# CITY OF PORTLAND, MAINE

**Project Name:** “118 on Munjoy Hill” Condominium  
12 unit residential, and 2 unit commercial, condominium  
**Project ID:** #2013-255  
**Project Address:** 118 Congress Street  
**CBL:** 16-D-2  
**Applicant:** Ed Theriault, EMT, LLC (118 Condominiums, LLC)  
**Planner:** Jean Fraser

On January 28<sup>th</sup>, 2014 the Portland Planning Board considered and approved a Level III Final Site Plan and Subdivision proposal for the construction of a 4-story 14 unit condominium building at 118 Congress Street, comprising 2 commercial units totaling approximately 1800sq ft floor area, 18 parking spaces on the ground floor to the rear of the commercial units, and 12 residential units above.

118 on MUNJOY HILL
118 CONGRESS STREET, PORTLAND, ME

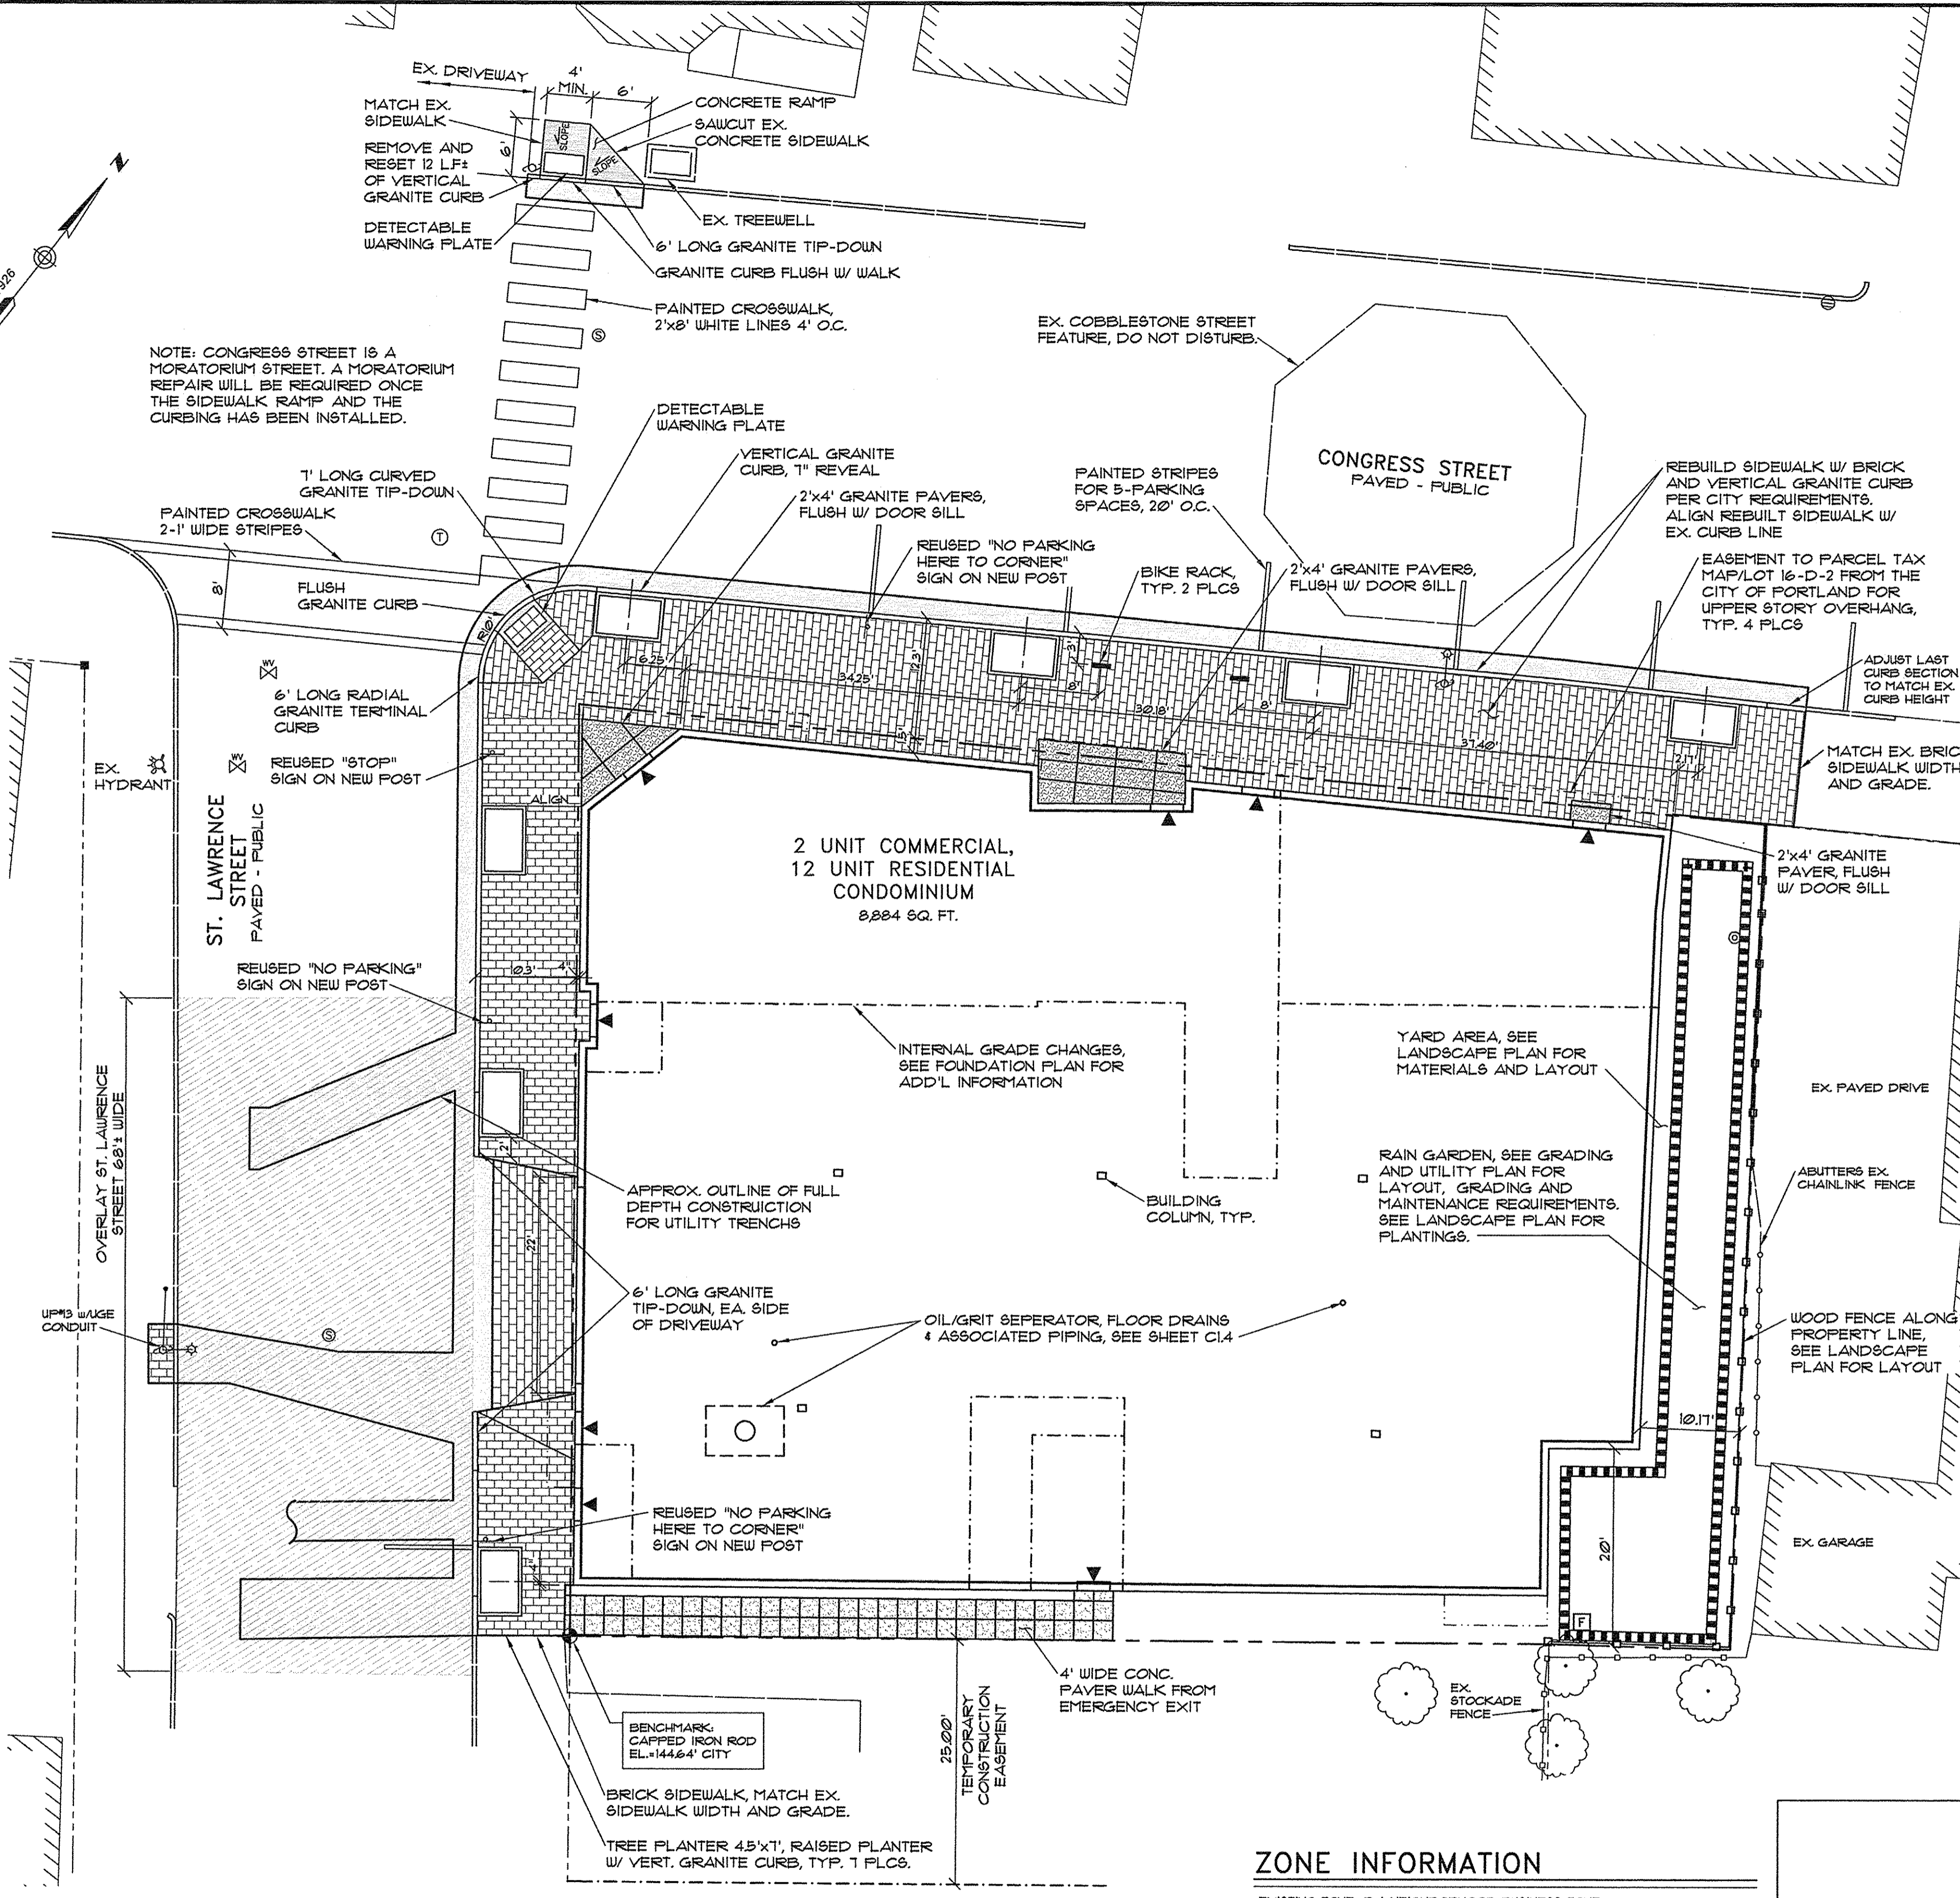
- iv. That the applicant may be required to install a crosswalk on Congress Street at the easterly side of the St. Lawrence Street intersection. The City's Crosswalk Committee may review the subject location and identify recommendations for installing a crosswalk. If deemed appropriate by the Crosswalk Committee the applicant shall be responsible for implementation of all features of the crosswalk including but not limited to pavement markings, signage, and ADA compliant ramps; and

**a) Street-trees** - the project proposes to plant (6) street trees, (4) along Congress Street, 'save' the existing Pin Oak and plant (2) new on Saint Lawrence Street. Updated plan shows the trees planted in raised granite tree wells with herbaceous planting. If on-street parking is proposed, the tree spacing or setback away from the curb to prevent the opening of car doors is important. The trees can be placed to match the in-between on-street parking, making sure there is good access to the sidewalk from parked cars. The residential tree standard of one tree per unit would also be a condition. Building overhangs over the public way should be discouraged to allow the street tree growth.

**'Tree Save'** - I was hoping the project could protect or save the large Pin Oak on Saint Lawrence Street, while the recent plan does show this, a recent site visit confirmed the crown of the tree would be severely impacted or one-sided, thus reluctantly yield to the fate of removal due to proposed building location. An additional street tree would be requested. Also, the proposed new tree on Congress Street near the corner of Saint Lawrence should be shifted slightly away from the intersection perhaps 2 - 3'. The recently planted American Elm along Congress Street should be saved and replanted by the city.

**Tree types** - It would be ideal if the tree types along Congress Street are all the same species. I would recommend the Columnar 'Musashino' Zelkova to be ideal due to the narrow space. See <http://www.jfschmidt.com/articles/musashino> and photo below.

The 'Red Sunset' Maple crown shape is too broad for this space. Along Saint Lawrence Street again a more narrow tree is needed, it could be Ginkgo 'Magyar' or 'Autumn Gold' cultivar (seedless), due to narrow sidewalk space. (photo 'Musashino' Zelkova, narrow vase shape crown)

- 4) The plans should note the size, material, and slope for the proposed storm drain connection to the combined sewer in St. Lawrence Street. Pending input from DPS, a wye connection to the sewer may be acceptable and the proposed sewer/drain manhole may not be needed. In addition, DPS would prefer that the storm drain pipe be installed "shallow" from the rain garden to the right-of-way, angling down to connect to the combined sewer (approximately 3' of cover in the road would be an acceptable depth). This will aid in potential future sewer separation efforts in St. Lawrence Street.

Drawing file: Re St Lawrence Decks / A1-02 - SECOND FLOOR PLAN.pdf

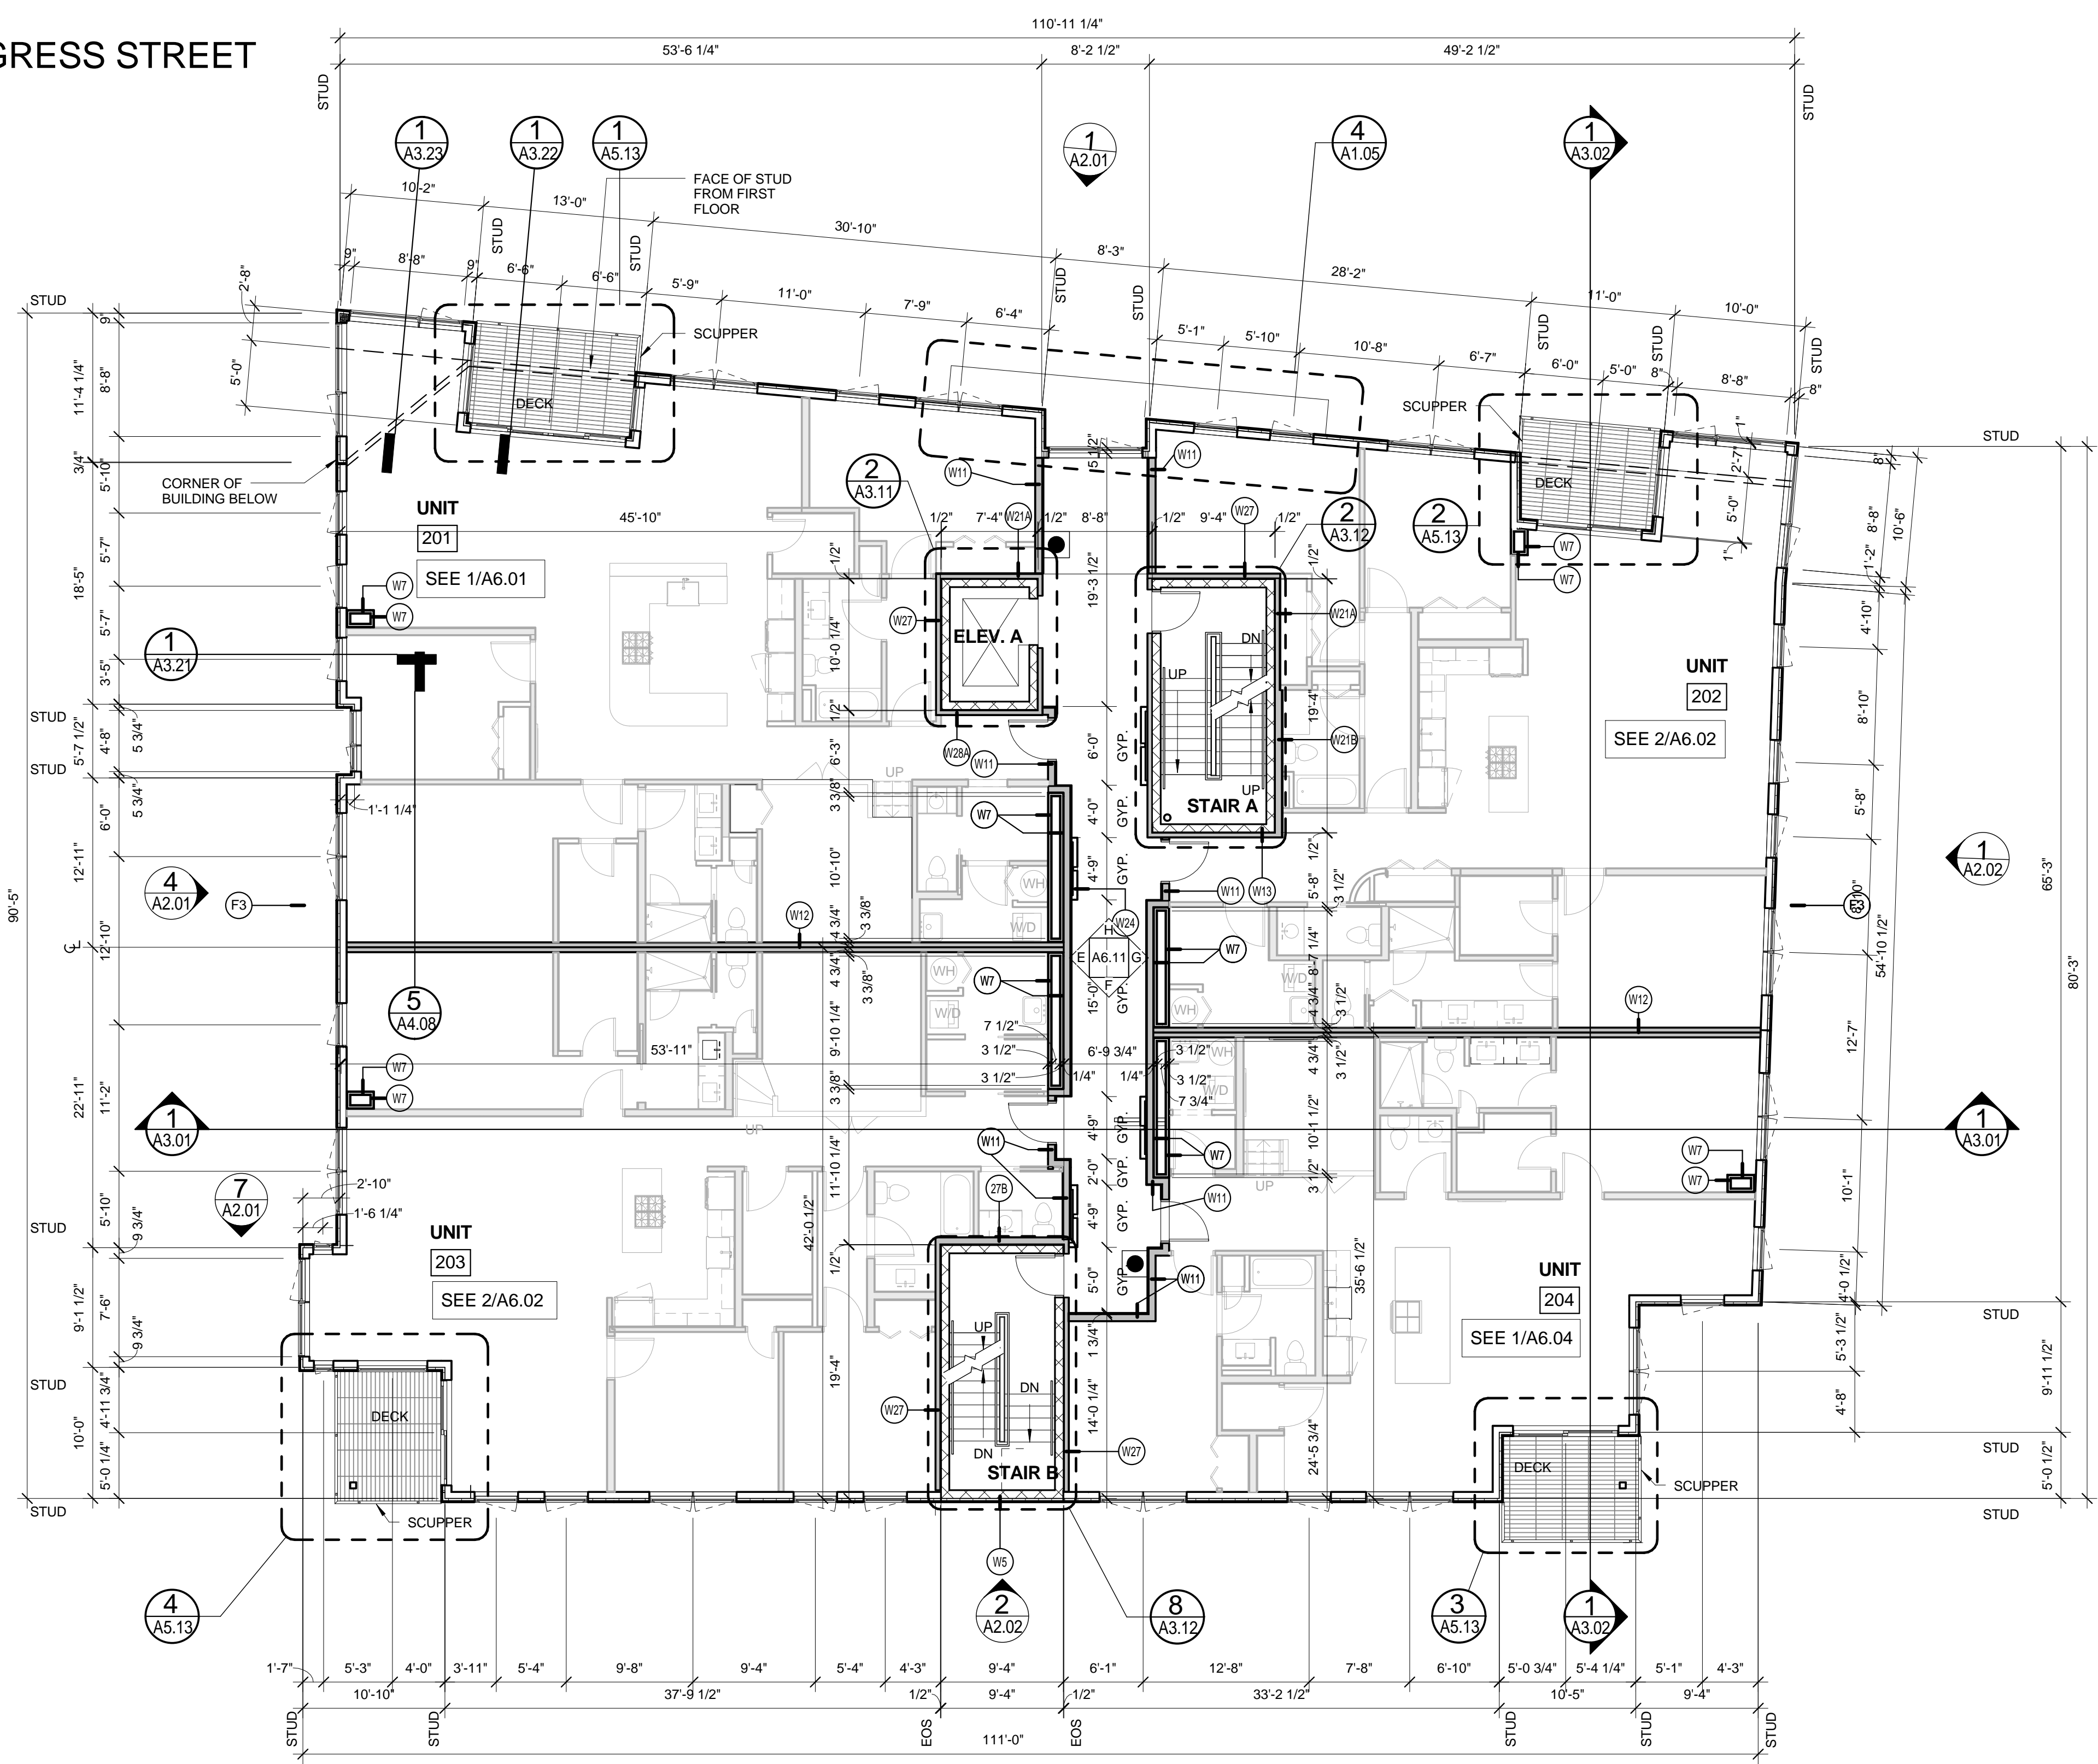
- i. The applicant shall submit a revised building design that results in the decks on St Lawrence Street being within the property boundaries while maintaining the current quality of design in regards to facade articulation and variation of form, for review and approval by the Planning Authority prior to signing of the Subdivision Plat; and
